Subject: SE-21-00012 Ski Acres - Notice of Application

TO: Community Development Services
FROM: Public Works Plan Review Team
DATE: July 1, 2021
SUBJECT: SE-21-00012 Ski Acres

SEPA Application Comments

RE: SE-21-00012 Ski Acres

6/24/21  
**CONCEPTUAL GRADING PLAN AND PROFILE**  
 SNOPASS SF LOFTS LLC  
 SKI ACRES ESTATES LOTS 6-11, AND 23-24

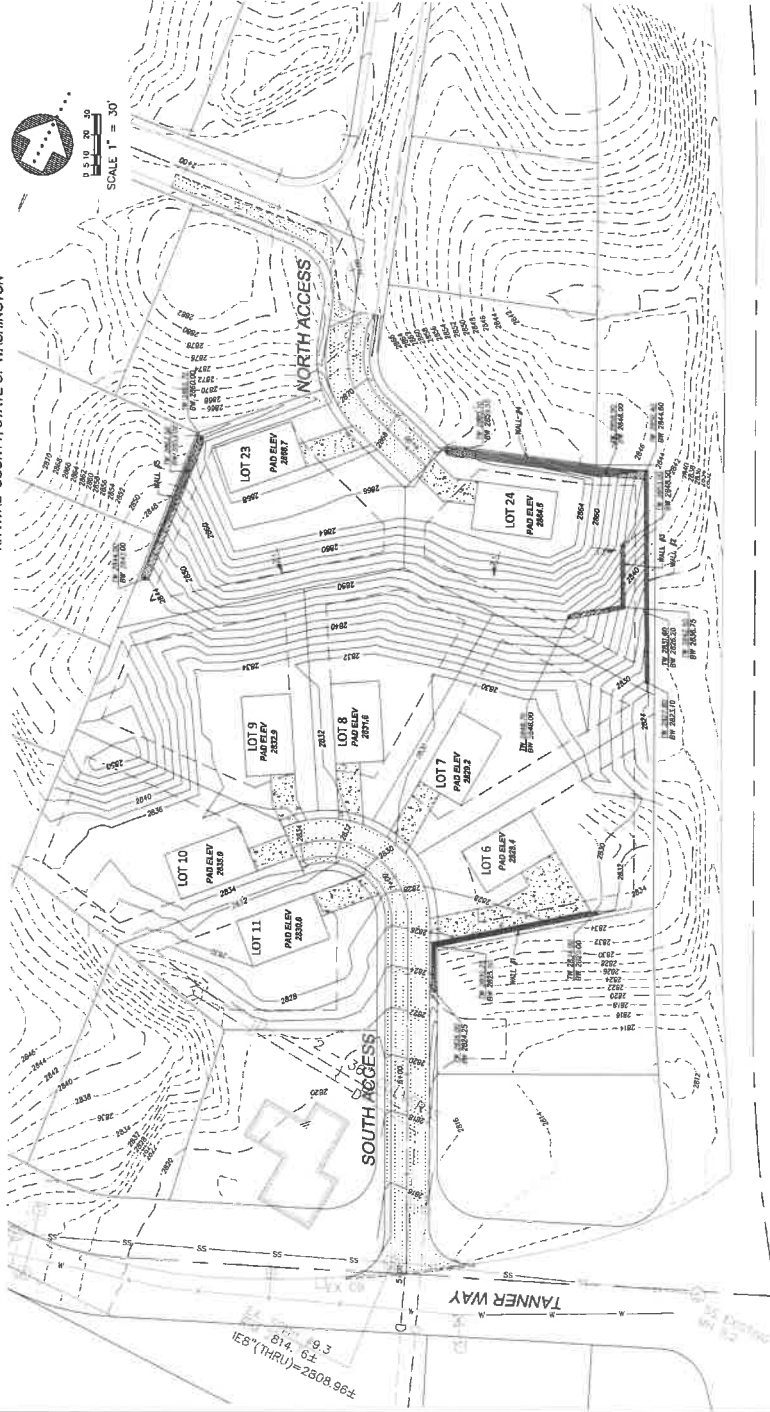
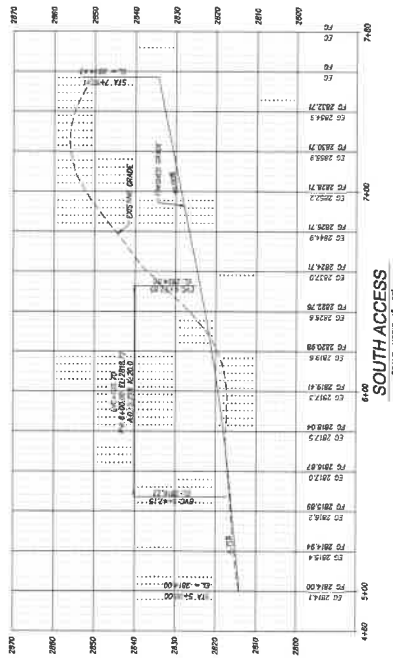
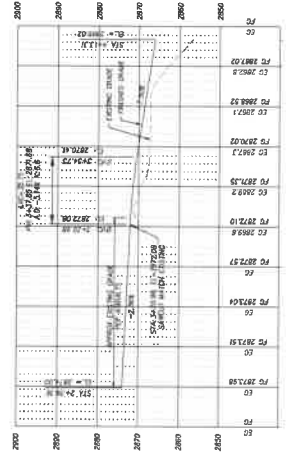
The proposed road and cul-de-sac do not appear to be compliant with International Fire Code for a turnaround. The road must be compliant with public works standards and international fire code. After reviewing the plot map cover sheet, I am not confident that a fire apparatus can enter and turn around in the proposed development. International Fire Code requires at least a 96-foot diameter turn-around. The width of the road must also meet county and IFC standards.

The plot map shows a fire truck turn around as shown above. This lane is not an acceptable alternative to a cul-de-sac. A turn-around compliant with IFC Appendix D is required:

- The proposed roadway shall meet or exceed current Kittitas County Road and Bridge Standards.
- The private road easement does not have adequate space for a turnaround. A turnaround will be required that meets International Fire Code design standards.
